CHECKLIST RESPONSES: HEADRICK RESIDENCE PHASE 2
Intake Screening - 2202-128 – Incomplete – 8822 SE 62ND ST, MERCER ISLAND

INTAKE COMMENTS PLANNING		Reviewer	Lauren Anderson	
		Email	Lauren.Anderson@mercerisland.gov	
		Status	Not Accepted – Resubmit Entire Submittal Package for Reviewer App	
Land Use actions Required				
<input type="checkbox"/>	Shoreline Permit			
<input type="checkbox"/>	Critical Area Review 1			
<input type="checkbox"/>	Critical Area Review 2			
1	<input checked="" type="checkbox"/>	Environmental Review (SEPA Checklist)		
	<input type="checkbox"/>	Accessory Dwelling Unit (ADU)		
	<input type="checkbox"/>	Lot Line Revision		
	<input type="checkbox"/>	Other		
Surveys Required Prior to Final Inspection				
	<input type="checkbox"/>	A building height survey is required prior to final inspection		
2	<input checked="" type="checkbox"/>	An impervious surface, lot coverage, and or hardscape survey is required prior to final inspection		
3	<input checked="" type="checkbox"/>	A property line/setback survey is required prior to final inspection

LAND USE APPLICATIONS

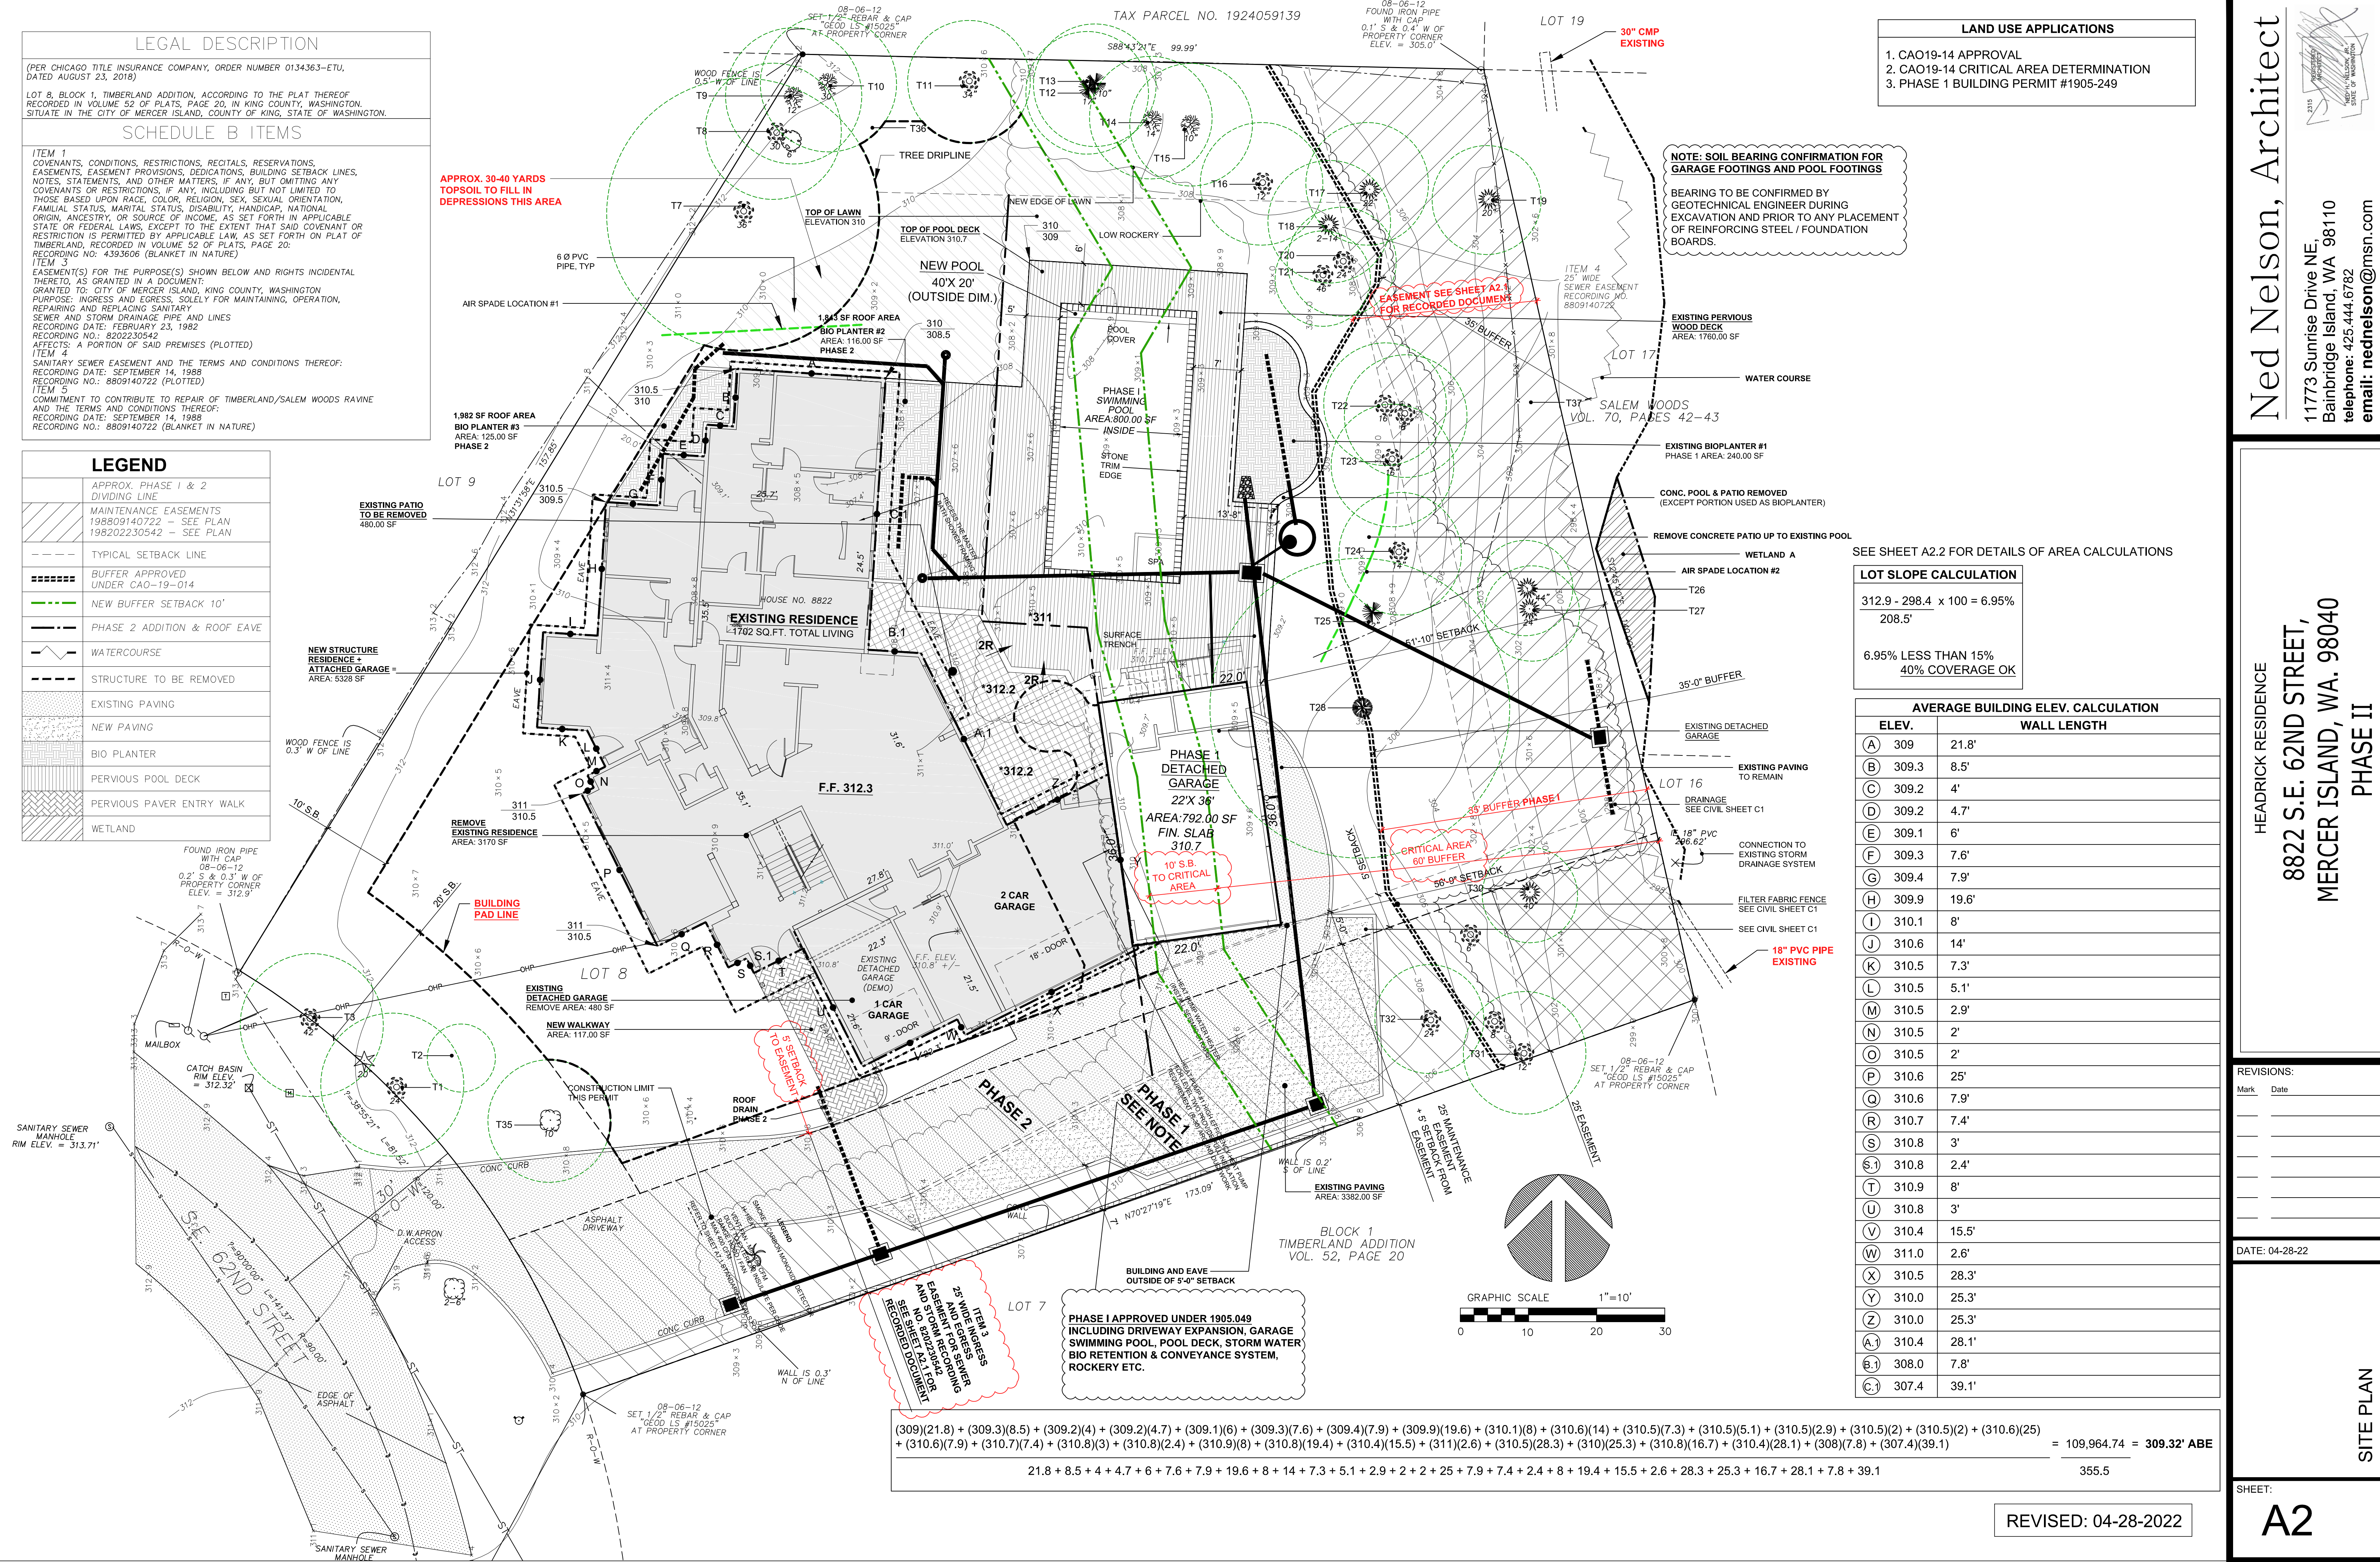
16 Show the buffers that were approved under CAO19-014. Reference CAO19-014 and note on plan set. Noting CAO19-014 is important to show that the old critical areas code applies to this project under CAO19-014 approval for the phase I and phase II work.

20 On the site plan please note that phase I was approved under 1905-249. Note what was approved during phase 1; i.e. driveway expansion, garage, swimming pool, pool deck, stormwater conveyance system, rockery, etc.

(10) Land use applications associated with this project as follows: phase 1 building permit 1905-249 and phase 1 critical areas CA019-014, approved as part of phase 1.
